# Fosse Green Energy

EN010154

8.14 Statement of Common Ground with  
Phillips 66 Limited

12 May 2026

FIGURE TITLE
400KV PIPELINE CROSSING
FIGURE NUMBER
Figure 1-1
DOCUMENT REFERENCE
EN010154/APP/X.X

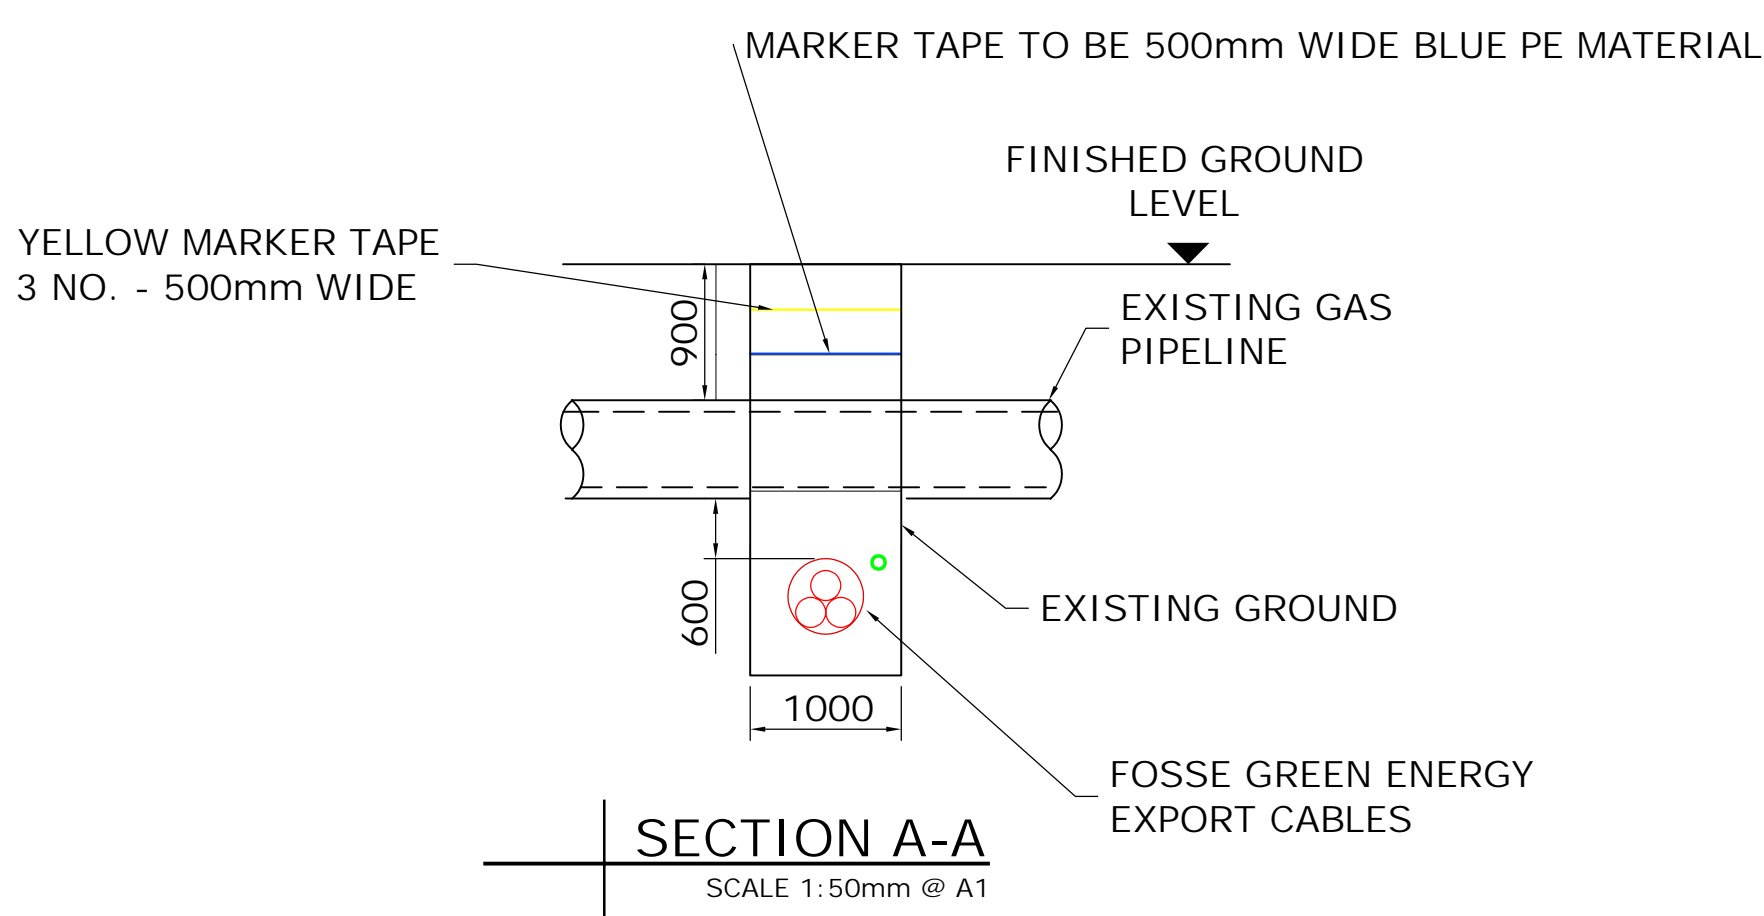
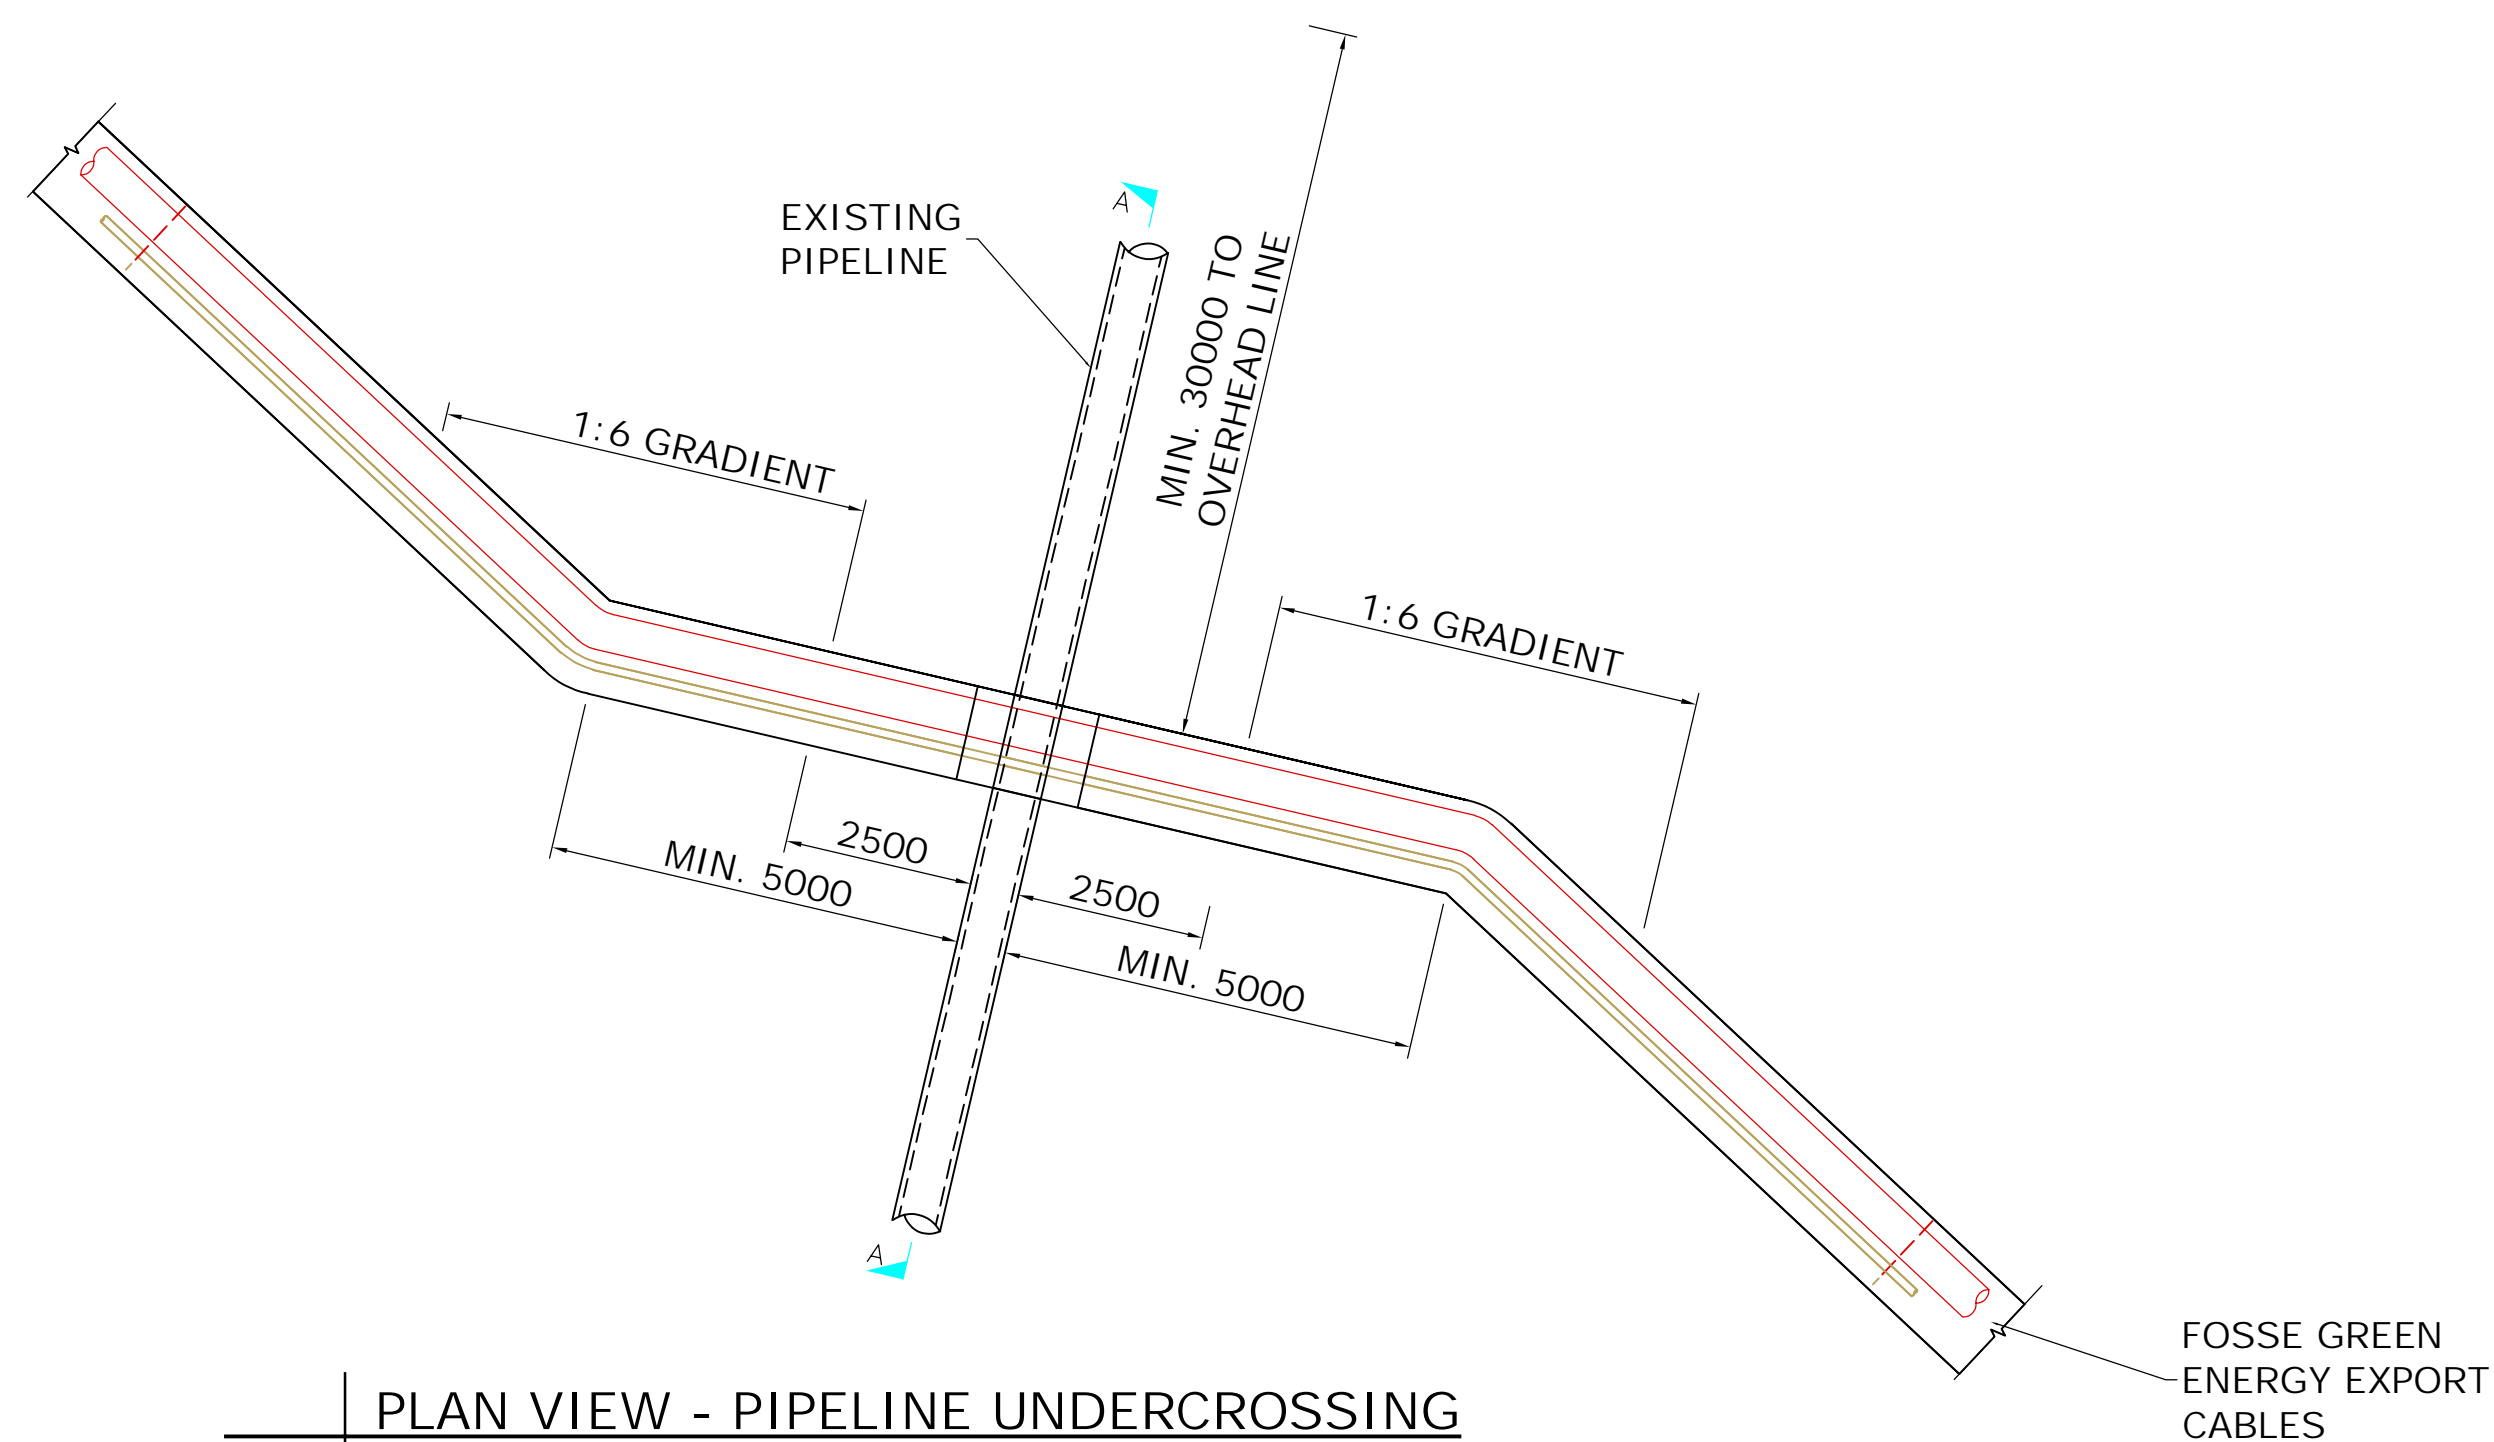
Reference	Description of Matter	Prax Position	Applicant Position	Status
4.2.1	Pipeline crossing	<ul style="list-style-type: none"> <li>P66's concerns in relation to safety and security of national fuel supply have been outlined in detail in its written and oral submissions.</li> <li>The Crossing Details are approved in principle subject to final approval by P66.</li> </ul>	<p>The Applicant's position with regard to the AC Interference Modelling Study (or Risk Assessment) is identified at matter 3.1.2.</p> <p>Further information on the proposed works, offset distances, and crossing angle are provided in the updated AC interference modelling report and engagement is continuing with P66 to secure appropriate protective provisions which reflect this.</p>	Under discussion
